11th September, 2016.

**Re: Oakdale South Industrial Estate, Erskine Park, Penrith LGA
Application No. SSD 6917 - Goodman Property Services (Aust) Pty Ltd
Lot 12 DP 1178389 and Lot 87 DP 752041 Milner Avenue, Erskine Park.**

Project	OAKDALE SOUTH
Title	S96 LAYOUT SOUTHERN BOUNDARY PLAN

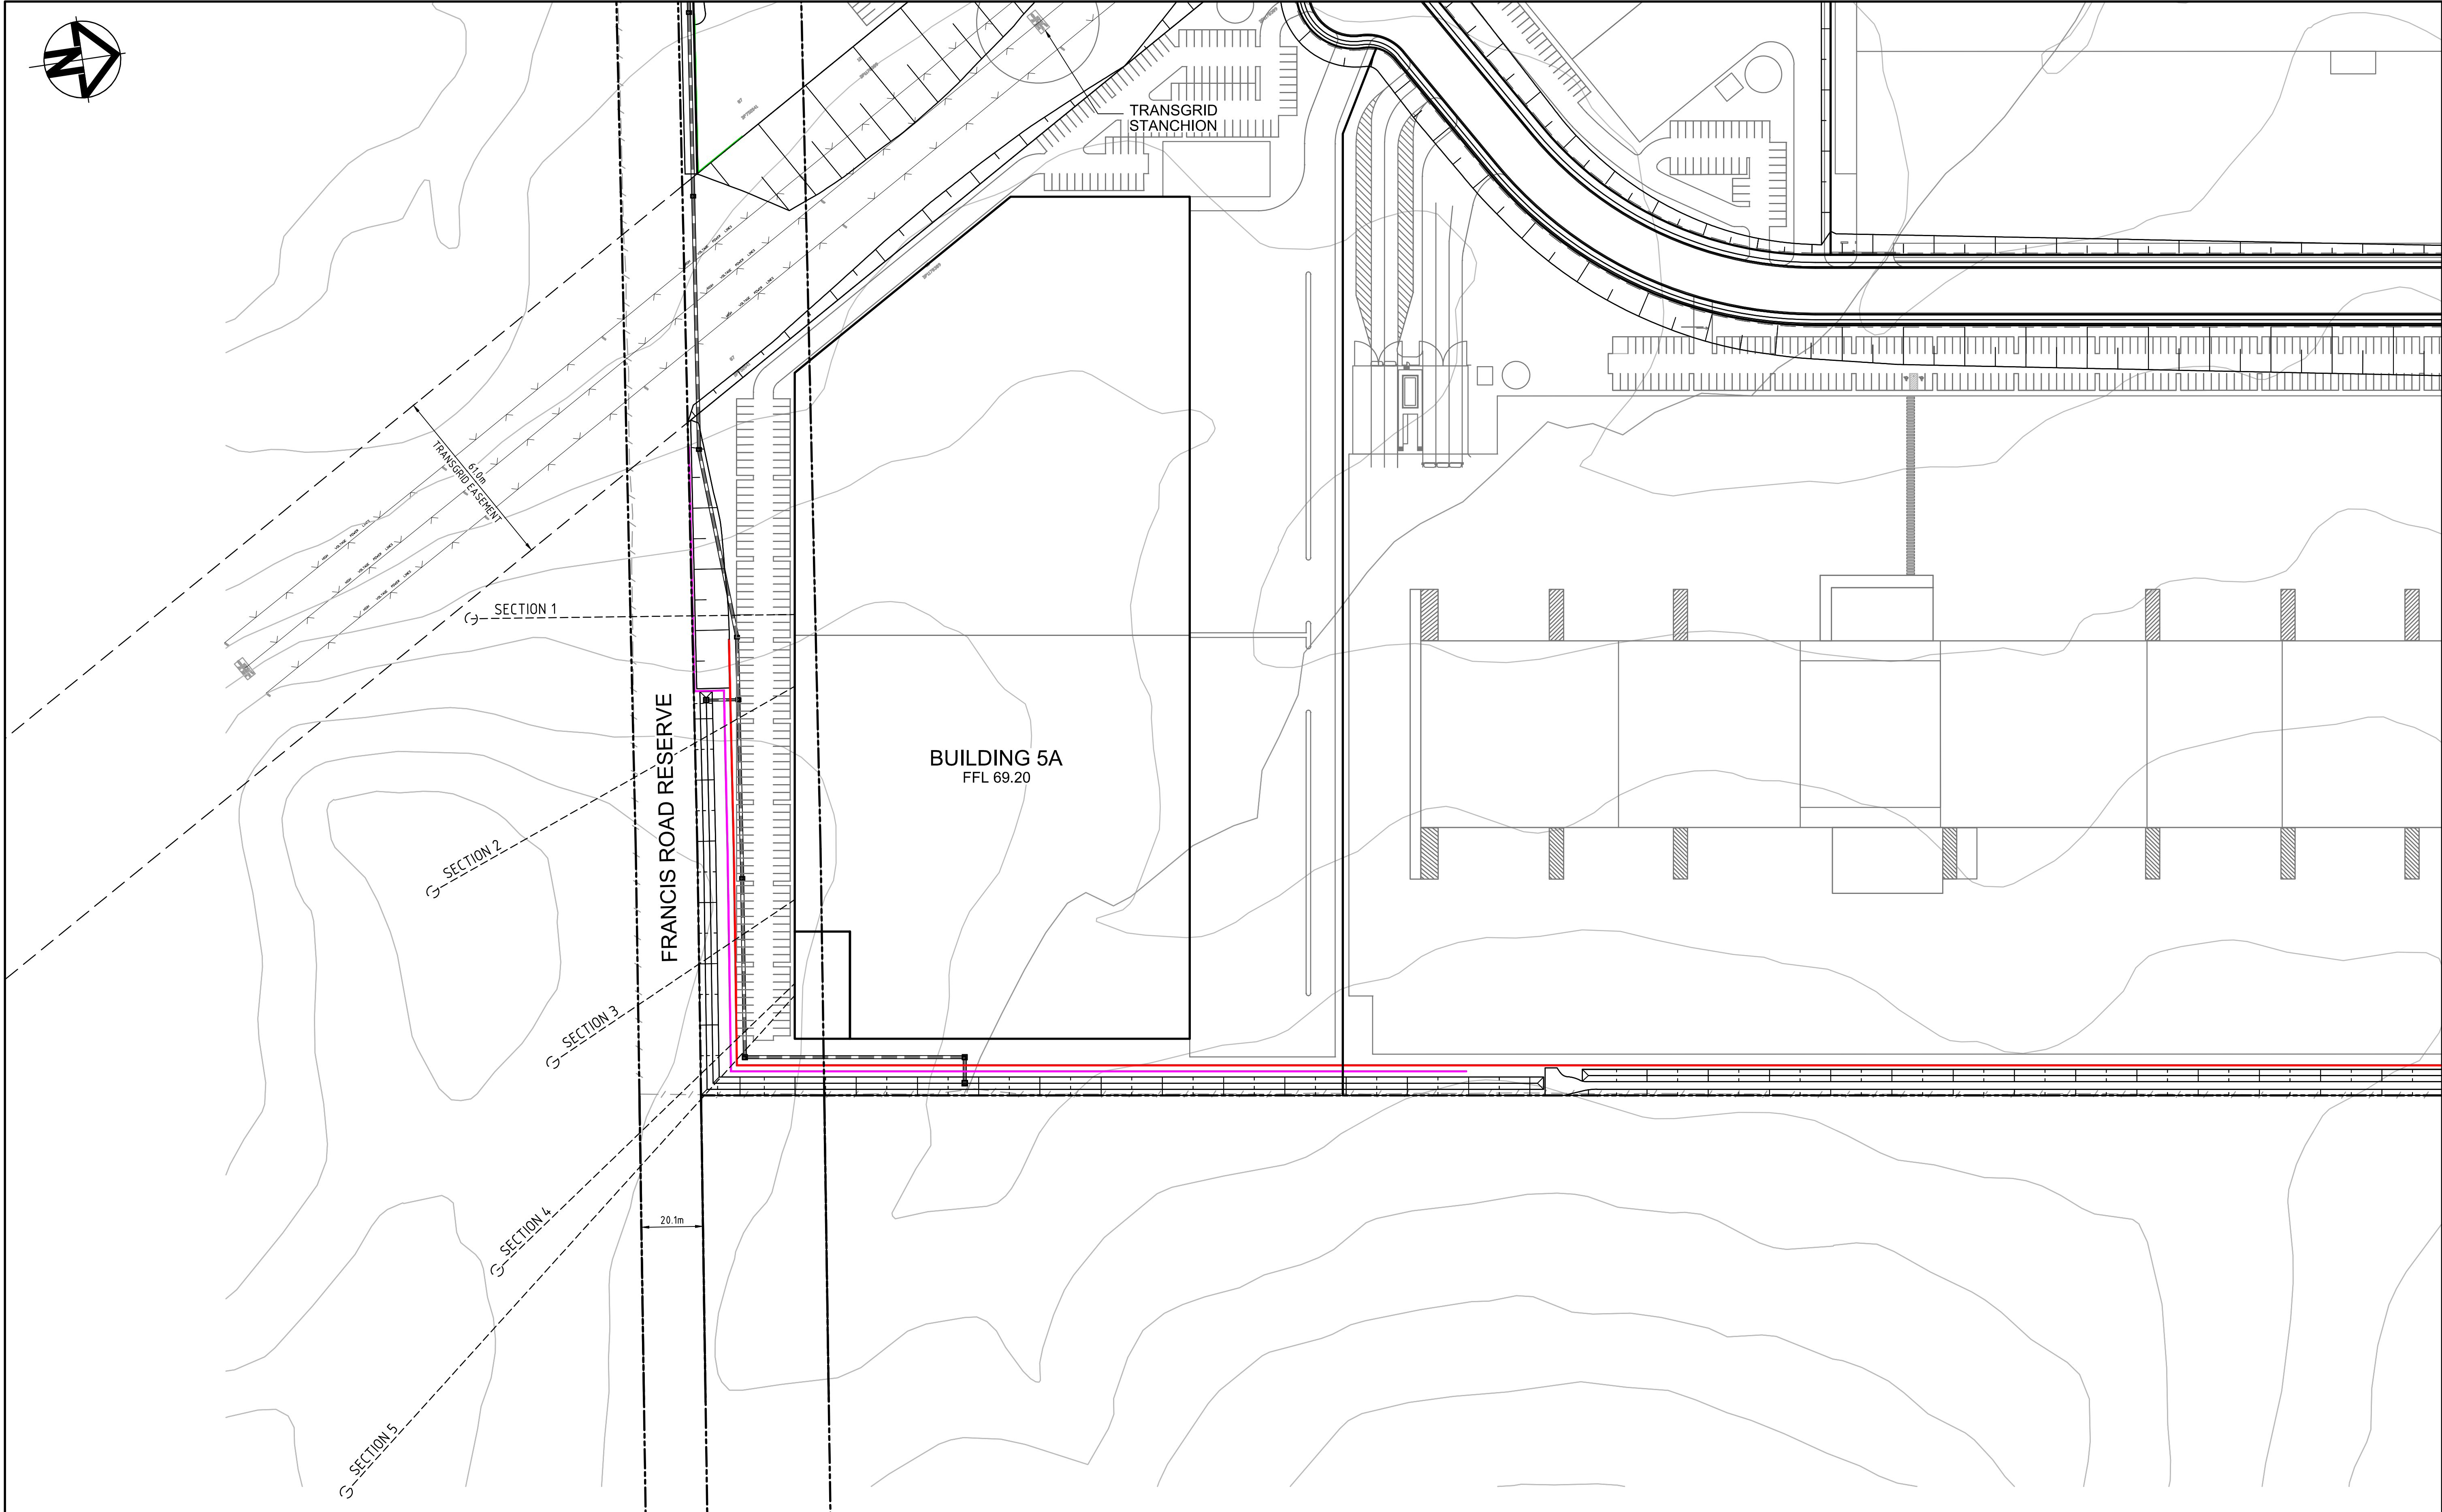
- 1 No loading/unloading docks or delivery bays or truck movements on the southern side of the warehouses proposed.
- 2 Increasing the landscape width from 12 metres to 30 metres for the entire length of Goodman's southern boundary except as required by transmission line restrictions.
- 3 Construct a 30 metre wide earth berm to a height of no less than 5 metres and to landscape as per AT & L drawing SKC 241 dated 08/09/2016.
- 4 Construct an acoustic wall on the northern side of the 30 metre wide earth berm the wall to be no less than 5 metres high above existing ground level.

- 5 Southern setback for industrial buildings not less than 50 metres from Goodman's southern boundary.
- 6 North of the proposed 30 metre landscape earth berm between the 7 metre tall retaining wall and the setback to the warehouse there is one area of 20 metres width to be used exclusively for staff car parking. This area is not be used for any other purpose i.e.

- A. No truck parking only passenger vehicles.
 - B. No storage of shipping containers.
 - C. No loading or unloading of trucks or shipping containers.
 - D. No waste storage.

- E. No forklift operation on the southern side of the industrial building.
- 7 Industrial buildings maximum height of 14 metres or RL 83
- 8 Proposed 30 metre landscape earth berm must be maintained/managed and irrigated as not to create a bushfire hazard as defined by NSW Rural Fire Service.

- 9 Landscaping of the 30 metre earth berm to be commenced immediately and to conform with landscape maintenance outlined in Richard Seddon's email of 08/09/2016.

- 10 To ensure the landscape earth berm is not compromised in the future by others that a "restriction to user" on title for landscaping 30 metres wide to be created along the southern boundary.
